STATE OF NORTH CAROLINA
DEPARTMENT OF TRANSPORTATION

June 29, 2010

Subject: **Corrections to the Application for Section 404 Nationwide Permits 13, 23, 33 and Section 401 Water Quality Certification** for the proposed replacement of Bridge No. 127 over Pinch Gut Creek on SR 1880 (St. James Church Road) in Catawba County, Federal Aid Project No. BRZ-1880(1); Division 12; TIP No. B-4062, \$240.00 debit WBS 33426.1.1

Reference: NCDOT permit application dated April 15, 2010

SECTION A-A (UPSTREAM)

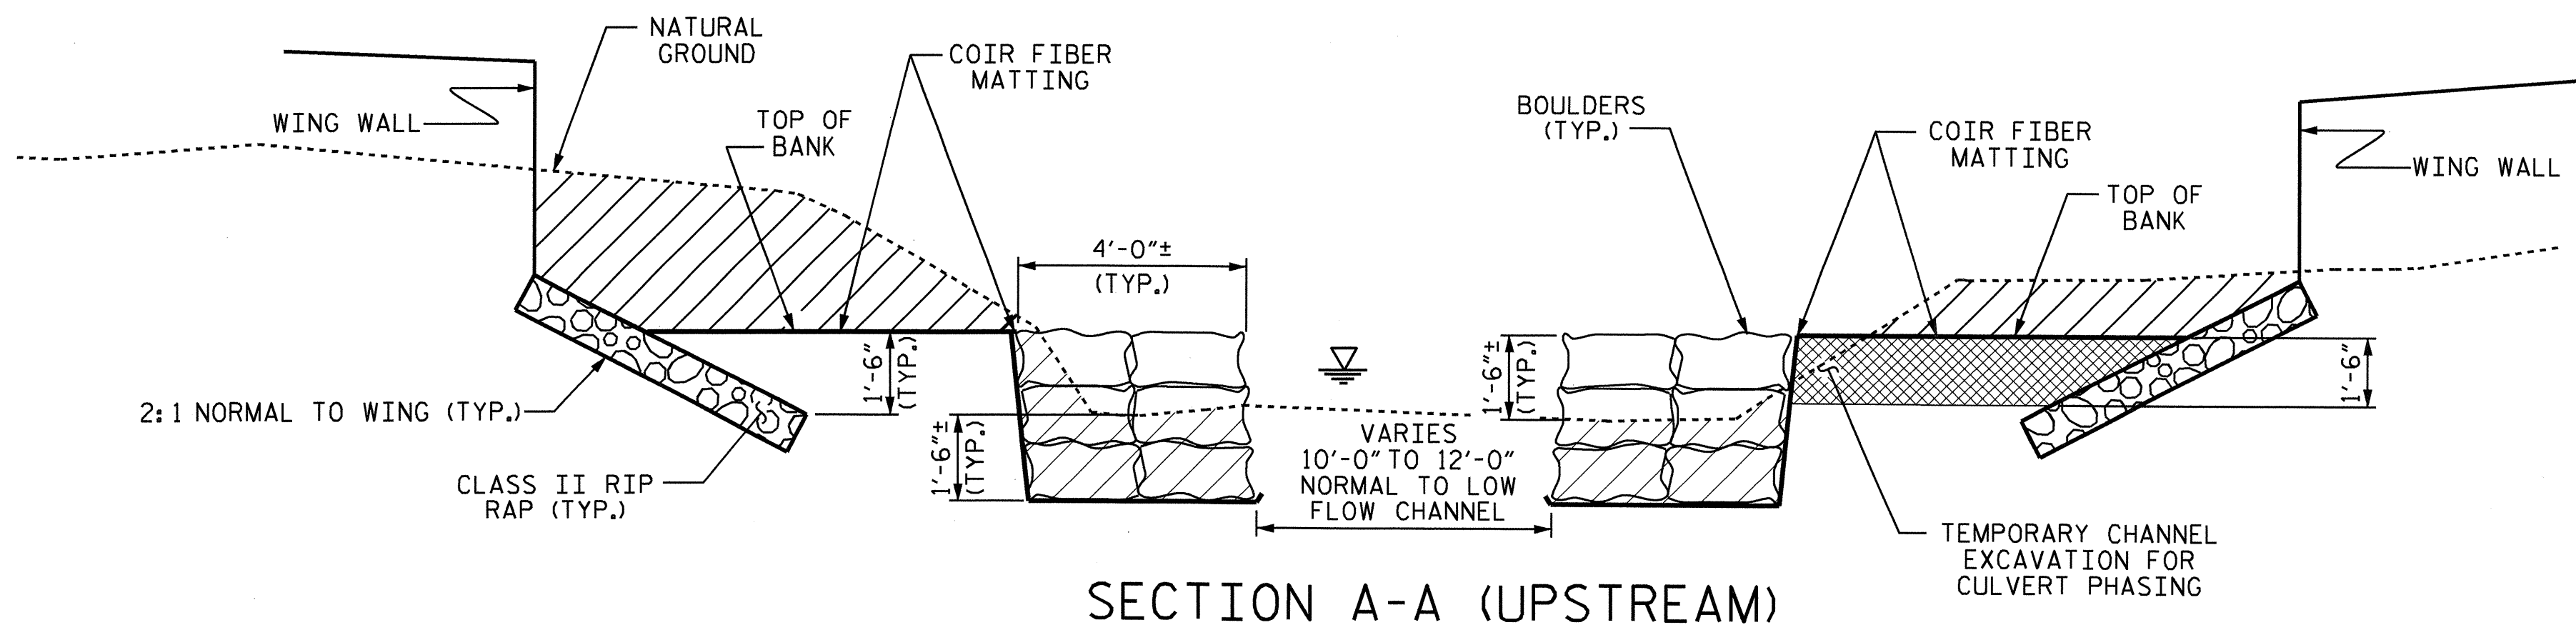
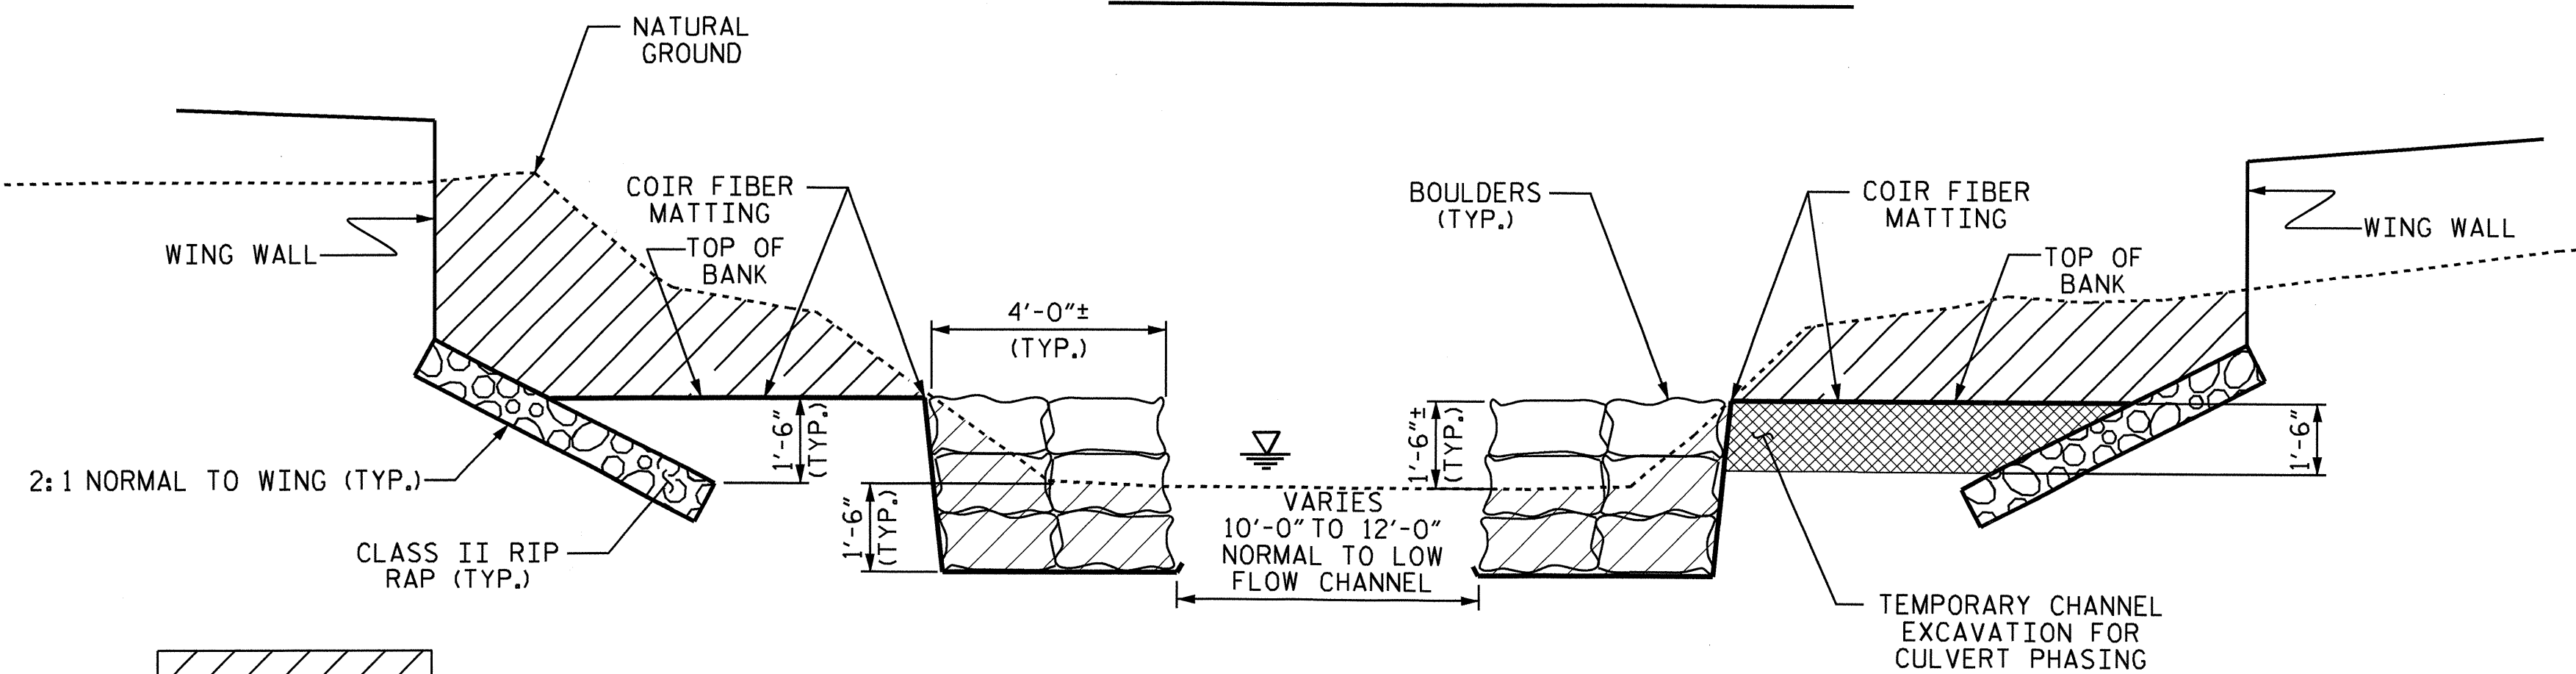
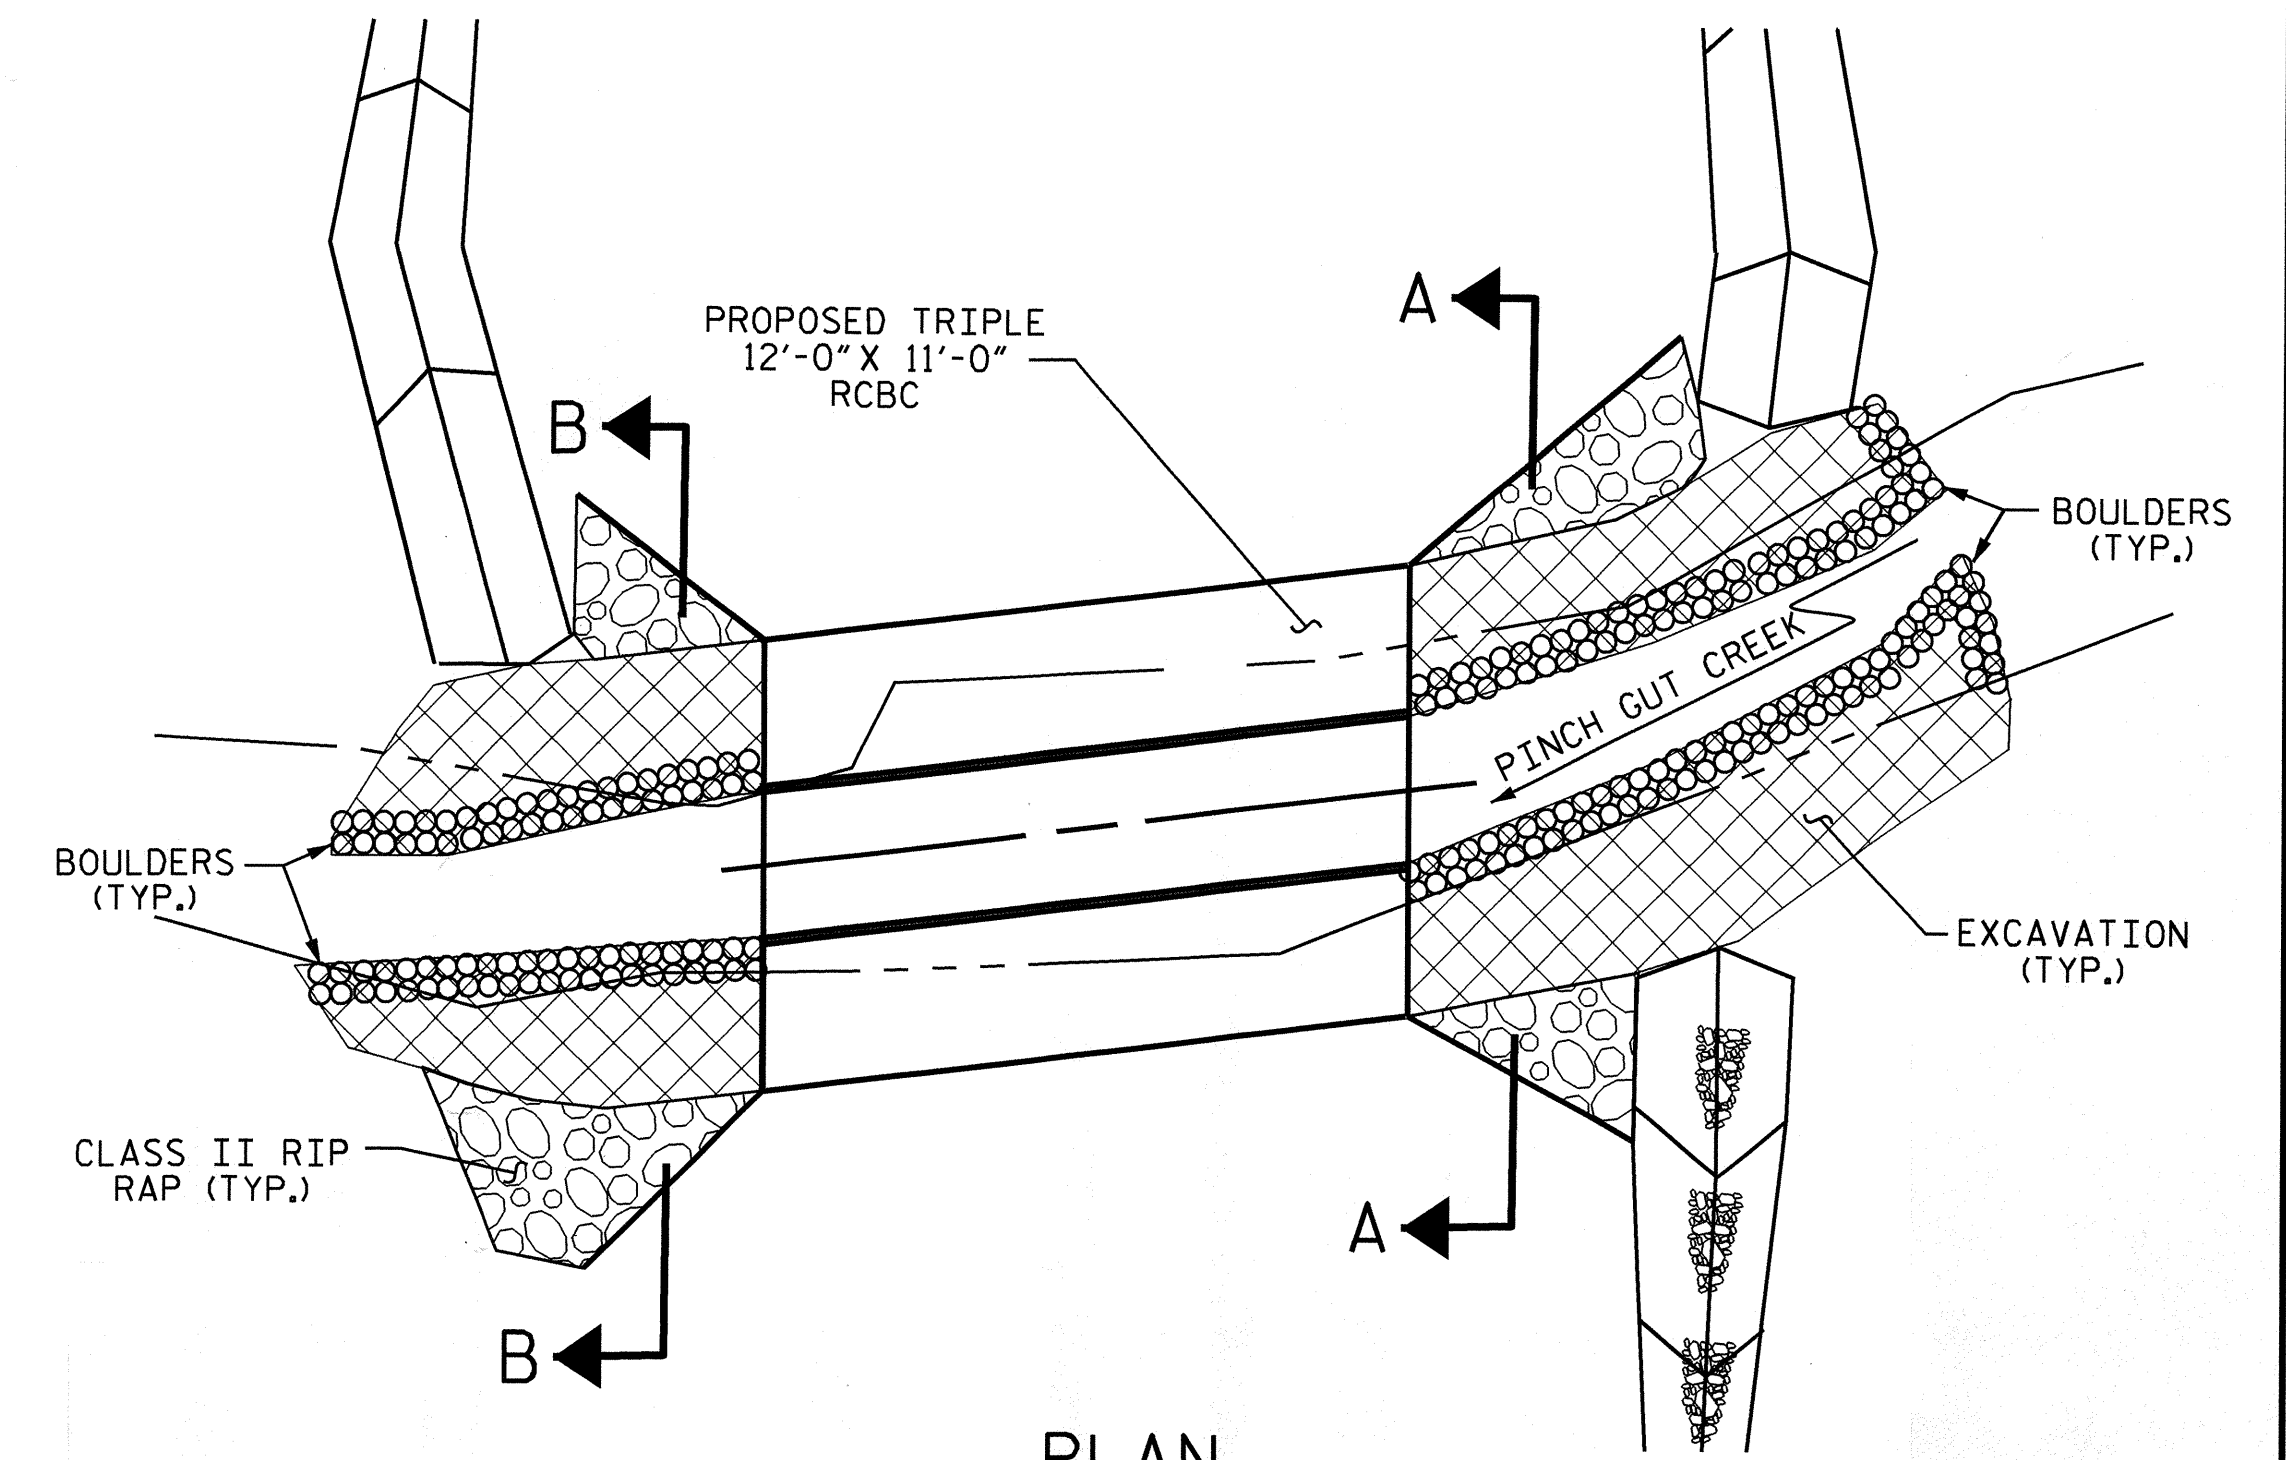
- Detail "D" was added to the roadway drawings.
- The size of riprap used in Detail "D" has been changed to Class I on the permit drawings.
- Detail of culvert (upstream and downstream)
 - Size of riprap has been changed to Class II on roadway drawings to match permit drawings.
 - Use of coir fiber matting at inlet and outlet of culvert has been added to roadway drawings to match what is shown on permit drawings.

FROM STA. 12+80 TO STA. 13+40 RT
FROM STA. 15+50 TO STA. 16+50 RT
CLASS B RIP RAP DDE = 125 CY
EST. 56.0 TONS
EST. 168.0 S.Y.F.F

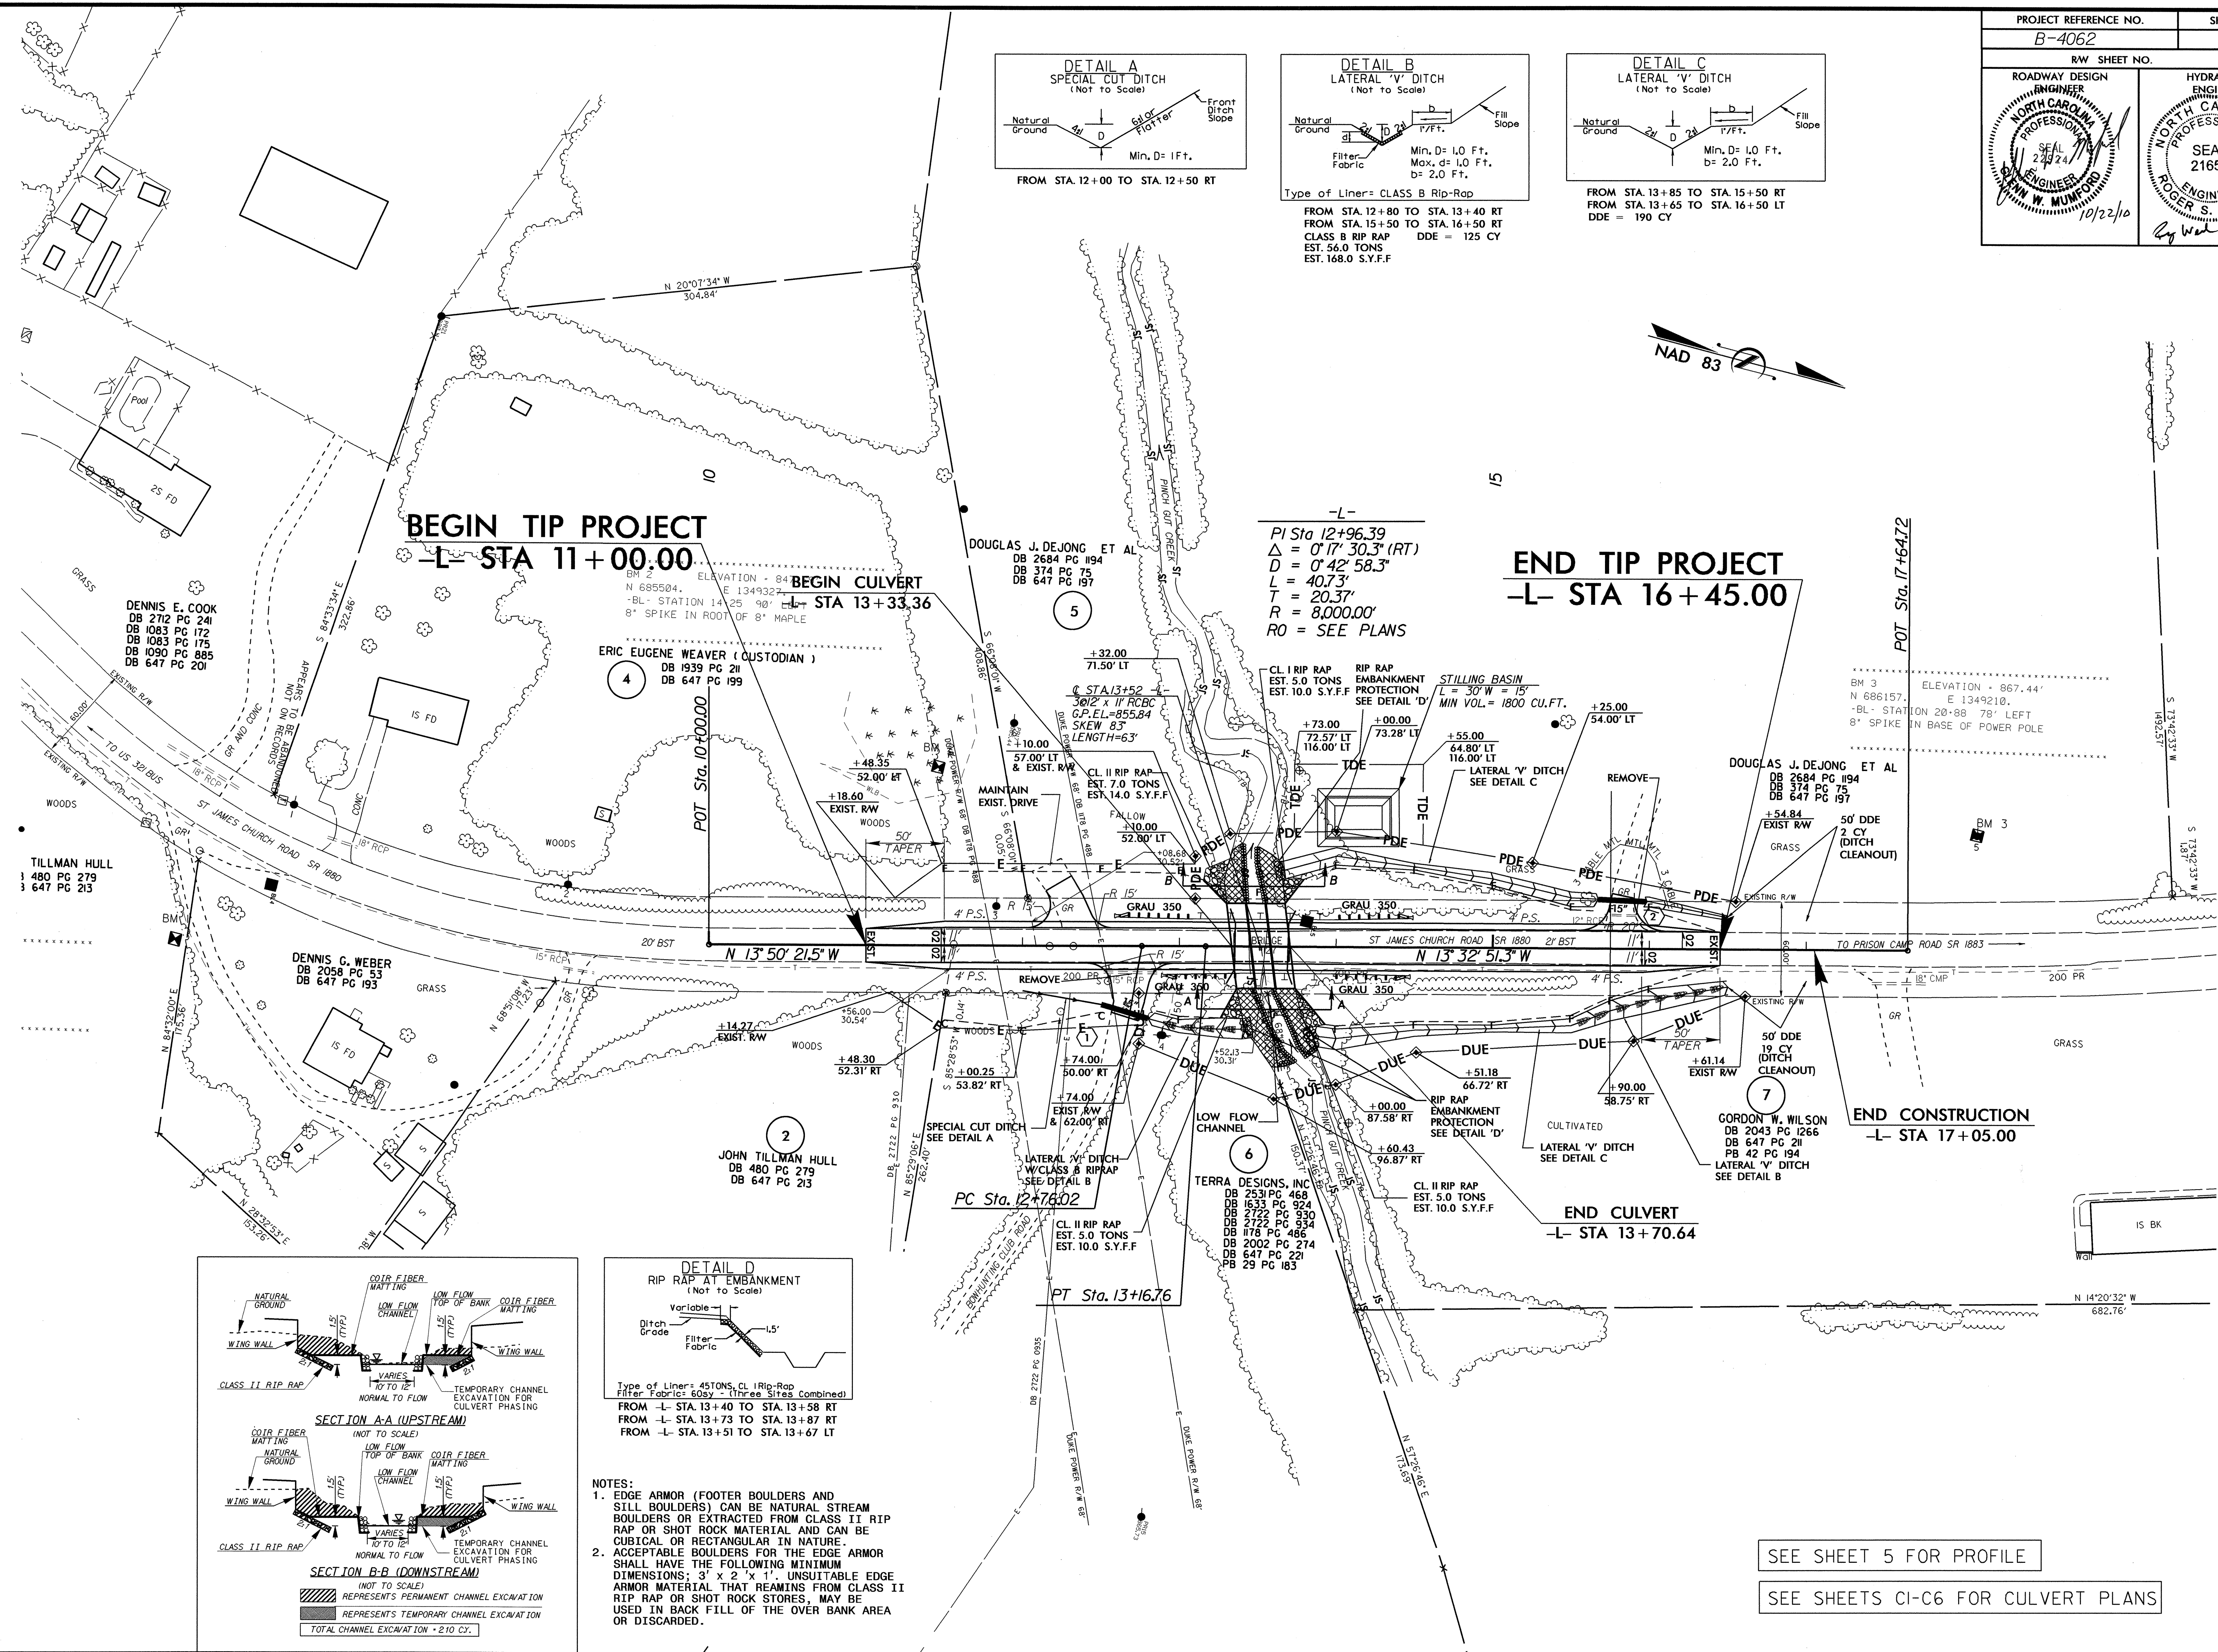
After the permit application was submitted, it was discovered that there were differences in the details between the permit drawings and roadway drawings. The differences in the details were in the size of rip rap that would be used and the use of coir fiber matting and filter fabric in some areas. Please see the attached revised Sheet 4 of the Roadway drawings and permit drawings (Sheet 6 of 7 and Sheet 7 of 7) to replace the previously submitted drawings. Listed below are the changes that occurred to the two sets of drawings:

It can be noted that rip rap placed outside of the installed culvert will be used to form floodplain benches.

With the above mentioned changes to the roadway drawings and permit drawings, all drawings are now consistent. There are no new or additional impacts due to these changes. Please replace the incorrect drawings with the corrected drawings attached with this letter. If you have any questions or need additional information, please call Jason Dilday at (919) 431-6693.
